Rezoning Transportation Analysis

Petition Number: 2024-008

Revision Log:

Date	Description
2-21-24	First Review (NK)
3-20-24	Second Review (NK)

RZ01 - REZONING PLAN

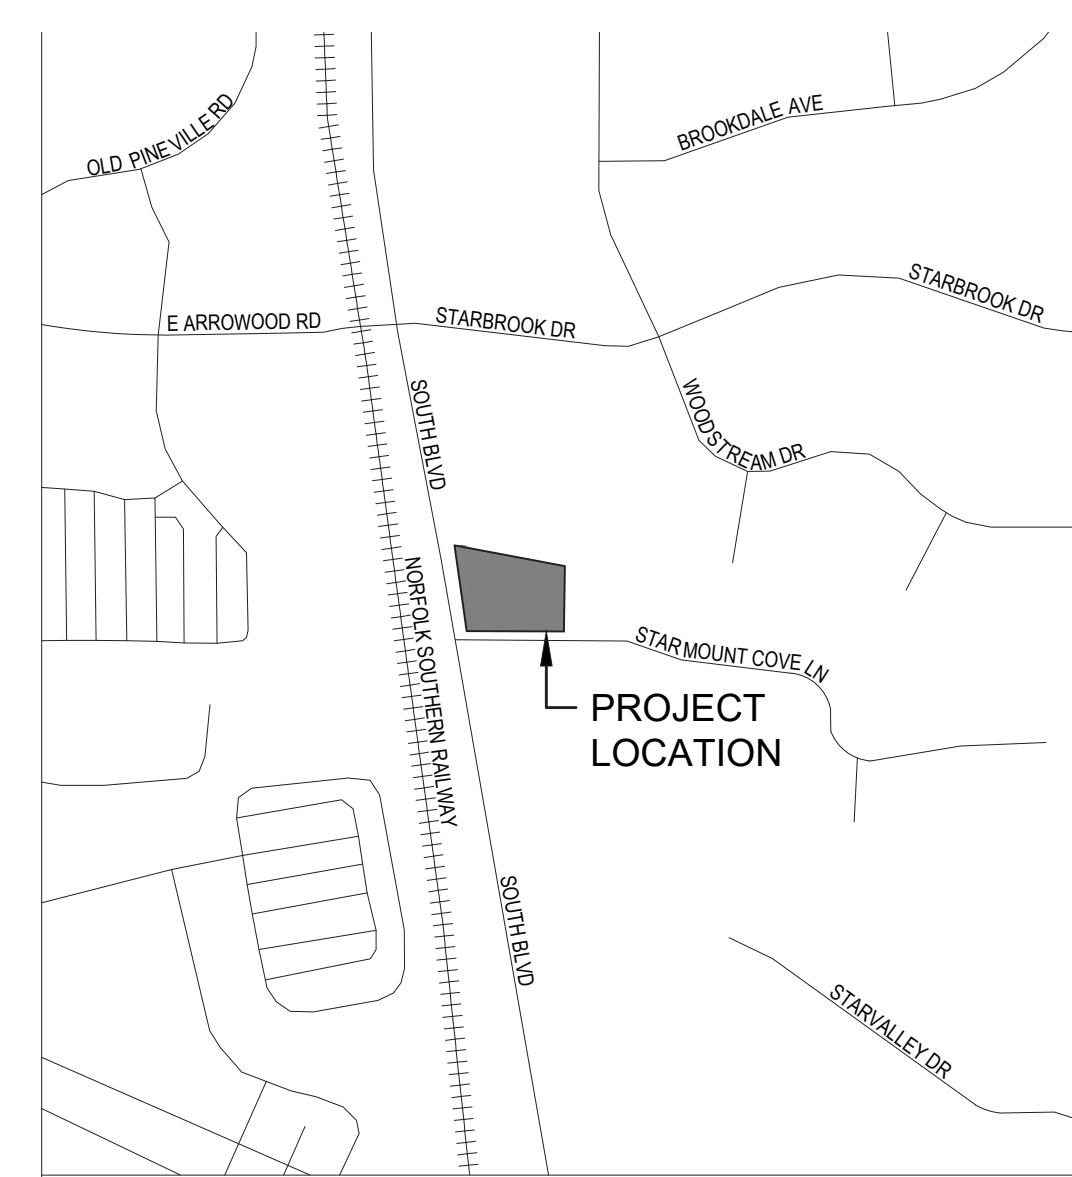
7. Revise site plan and conditional note(s) to commit to removing driveway located on South Boulevard. Per Charlotte Streets Manual table 2.1, access priorities would be as follows before individual driveway:

1. Side street
 2. New street
 3. Shared driveway and/or
 4. Cross-access

Clarifying Comment 3-20-24: NCDOT / CDOT will agree to allow a 60 degree skewed right-out driveway off of South Blvd, and the median will need to be extended past the driveway entrance.
